PLANNING AMENDMENT

H11/0370/97

Applicant: Mr & Mrs R Parkin
Old Gate Dairy
St James Road
Long Sutton
Spalding Lincs PE12 9AZ
Description: Erect detached garage and
outbuildings

Amendment: Roof pitch reduced, window type and garage door amended
(Drawing No. 275-1A)

275-1 A

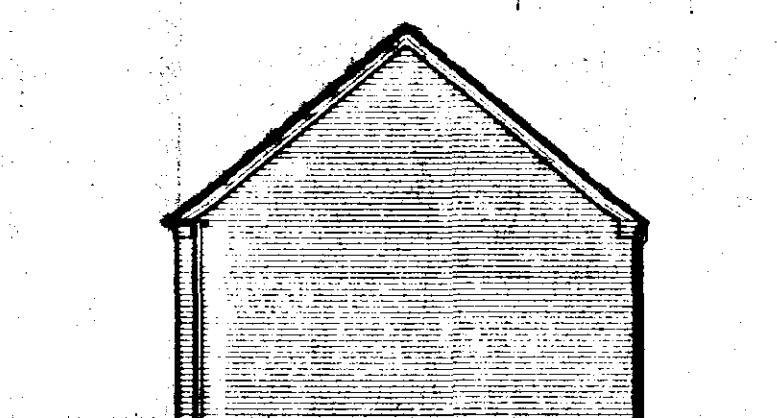
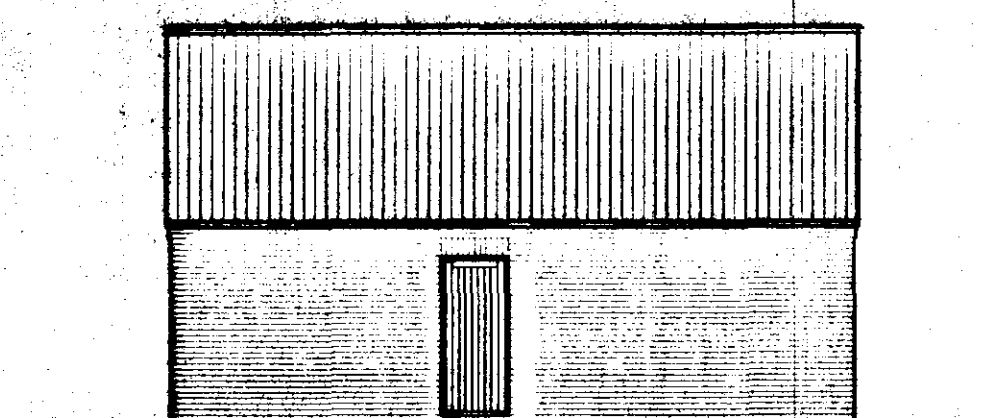
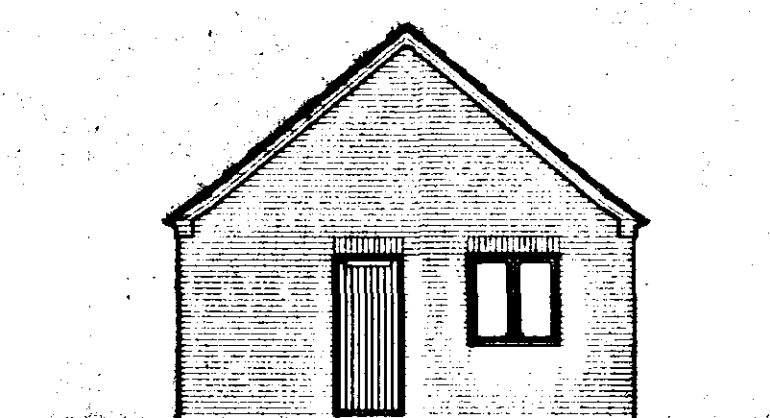
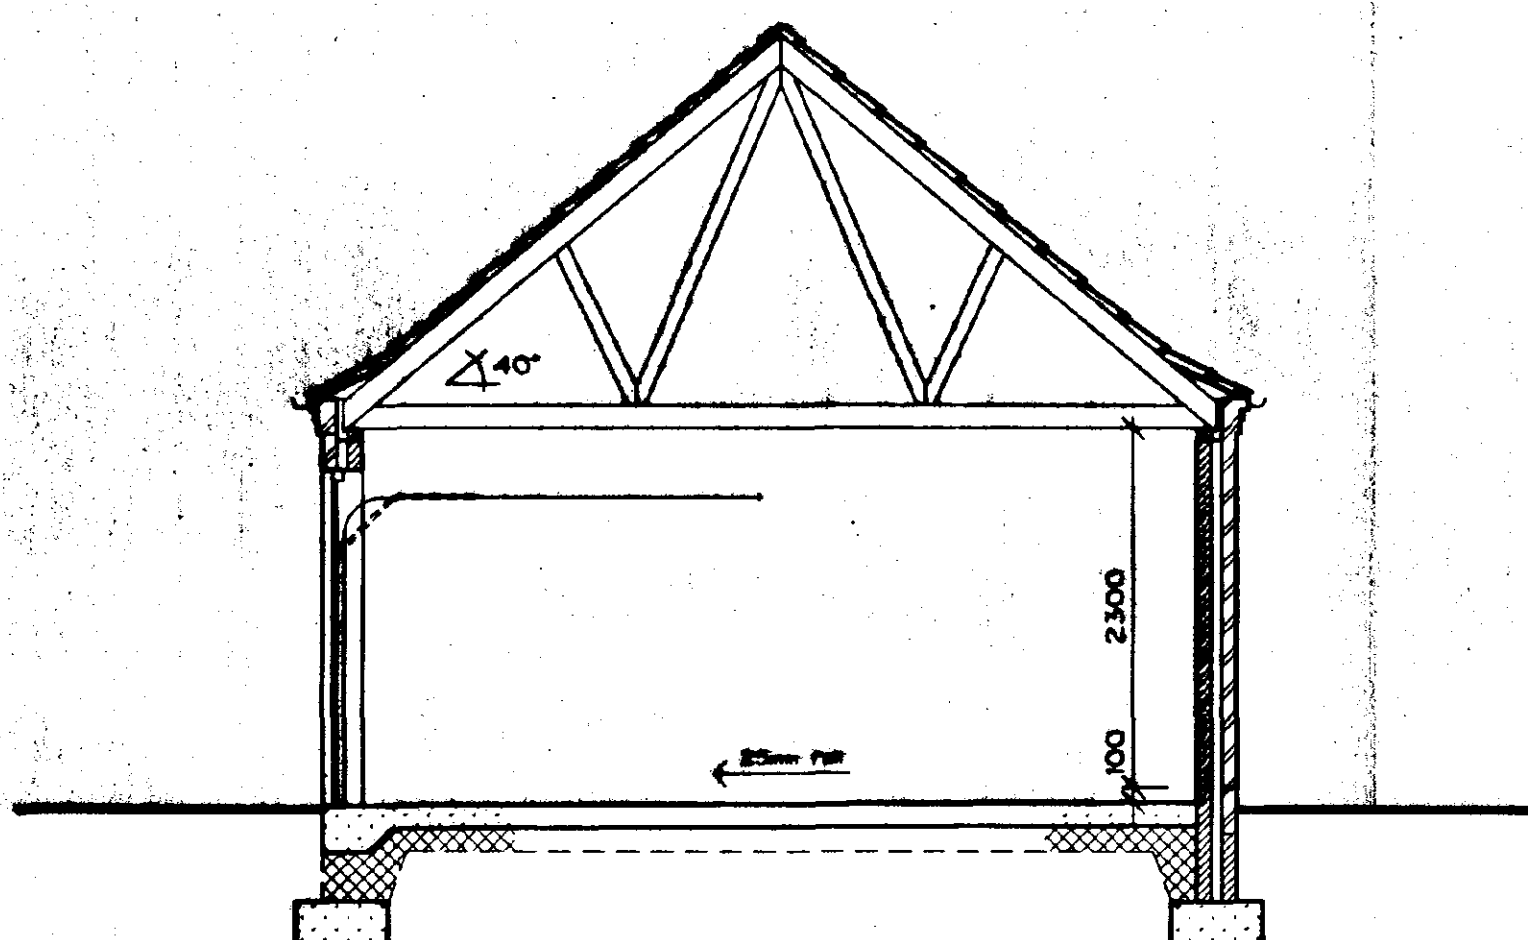
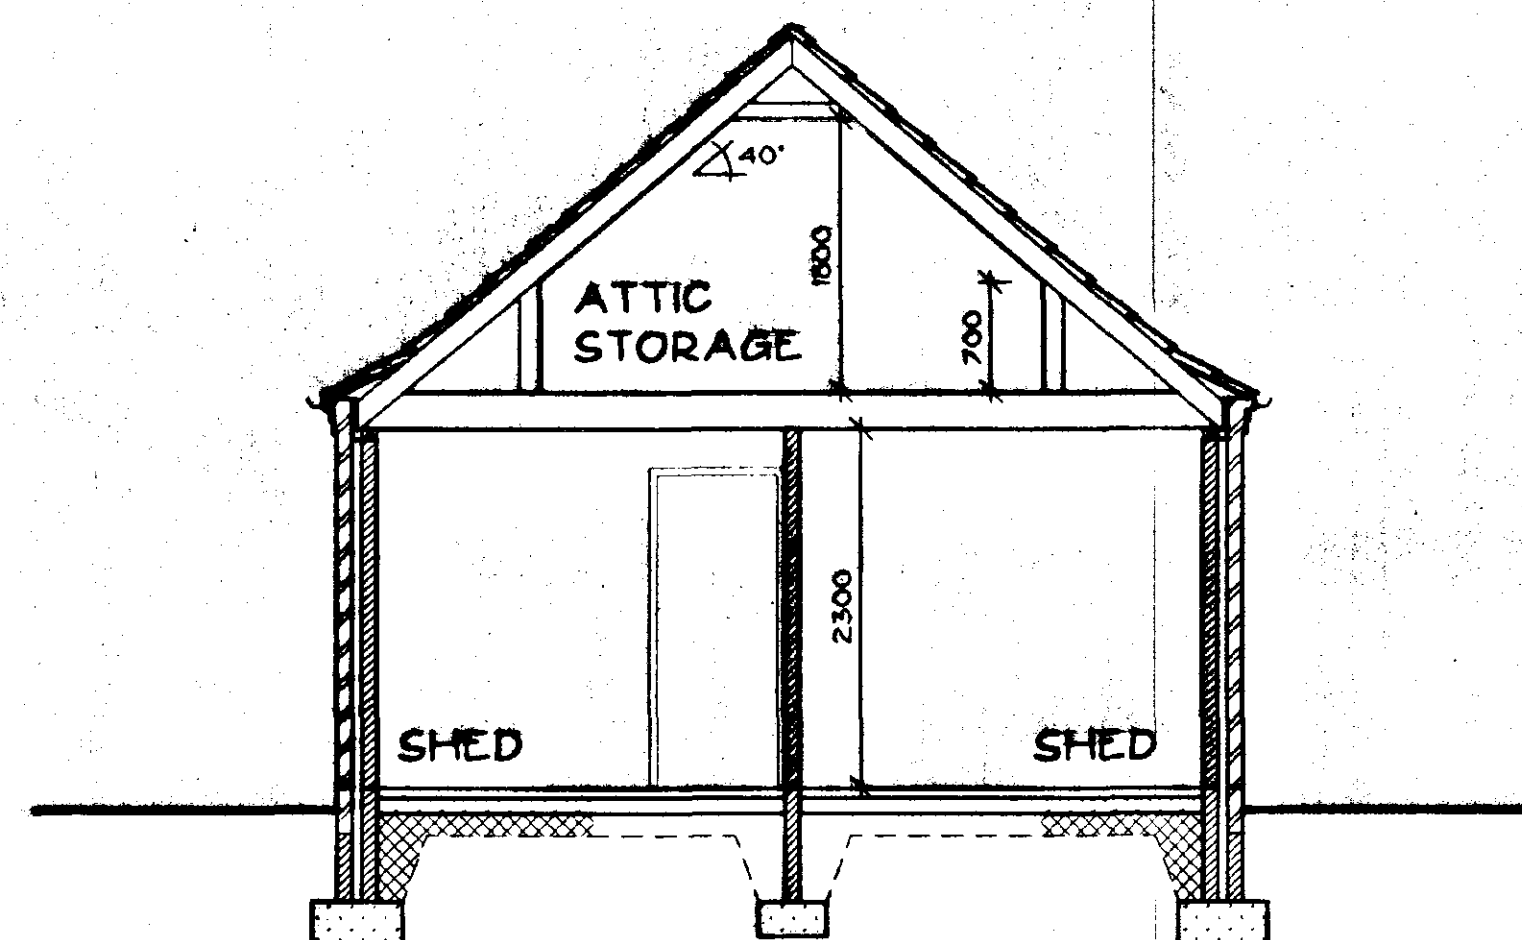
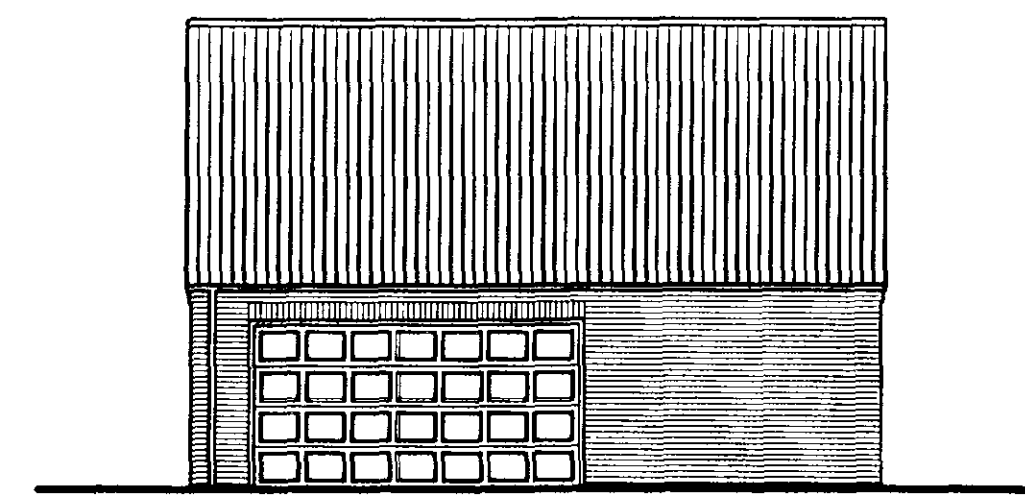
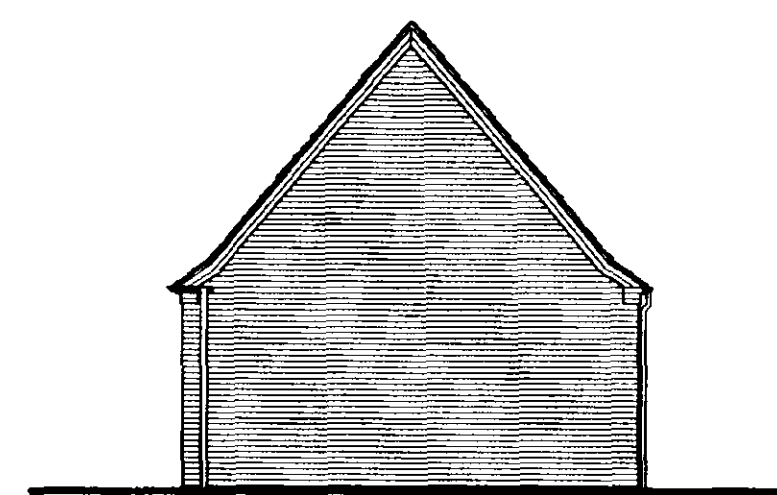
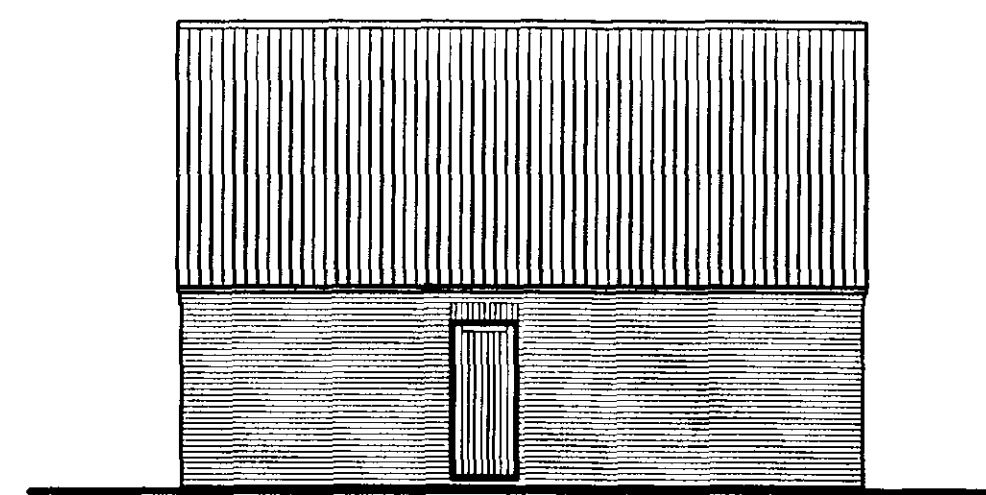
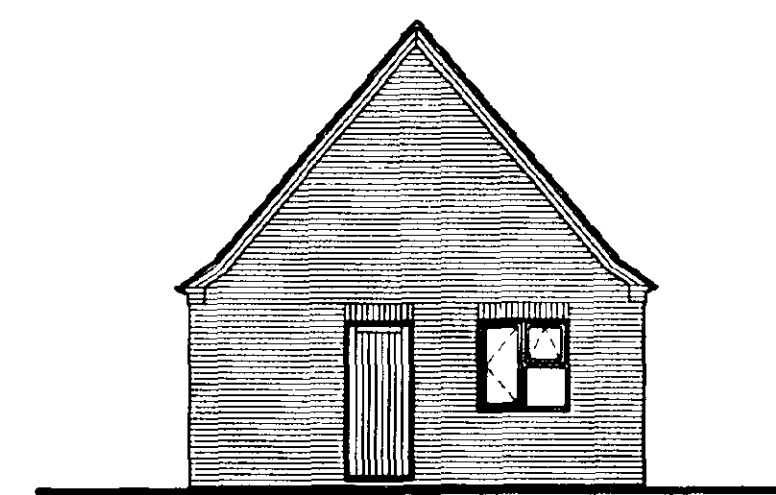
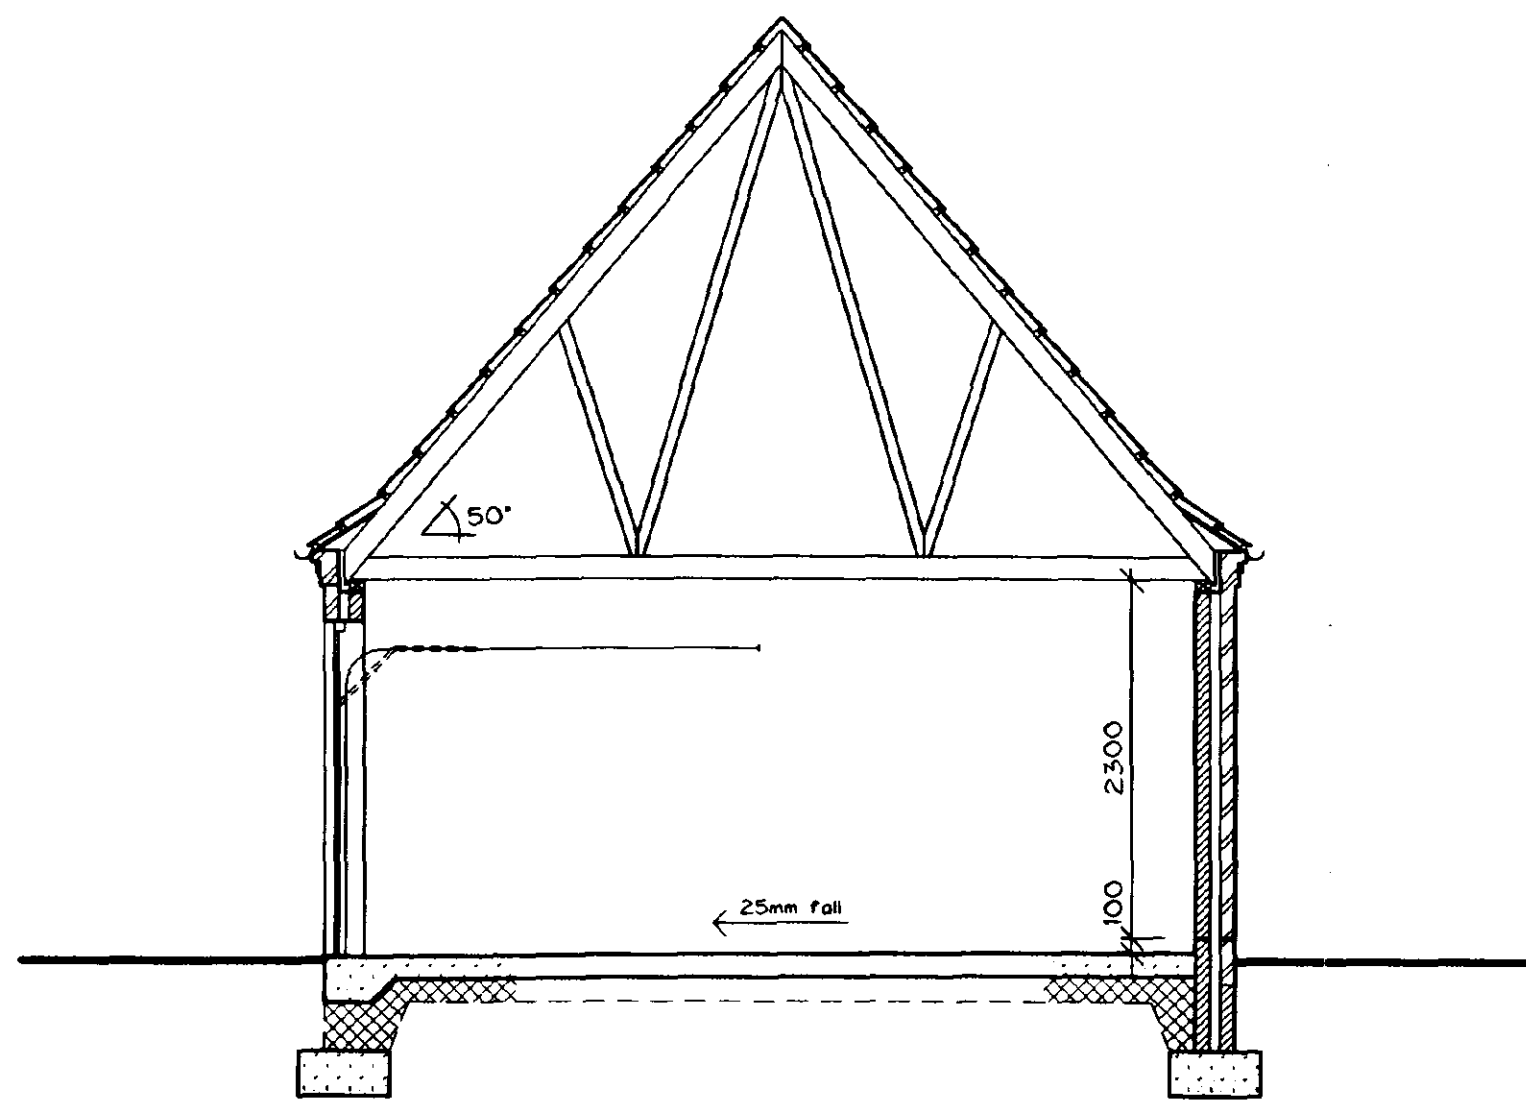
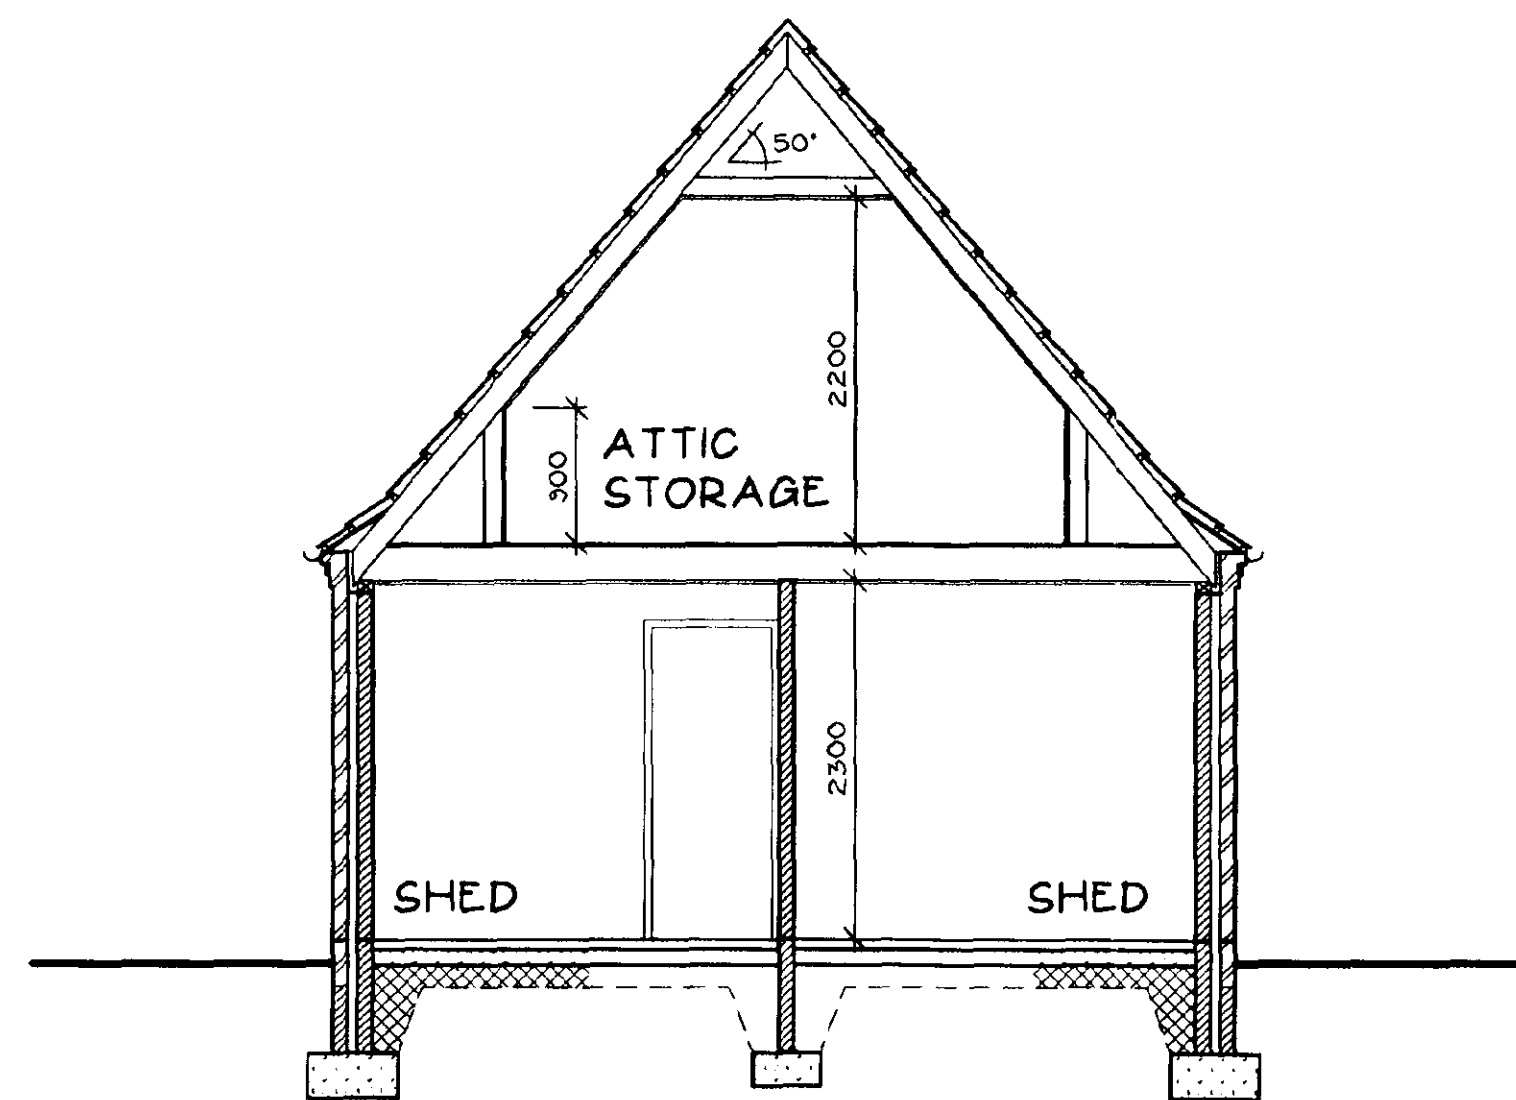
Pitched Roof
Window TYPE
Garage Door
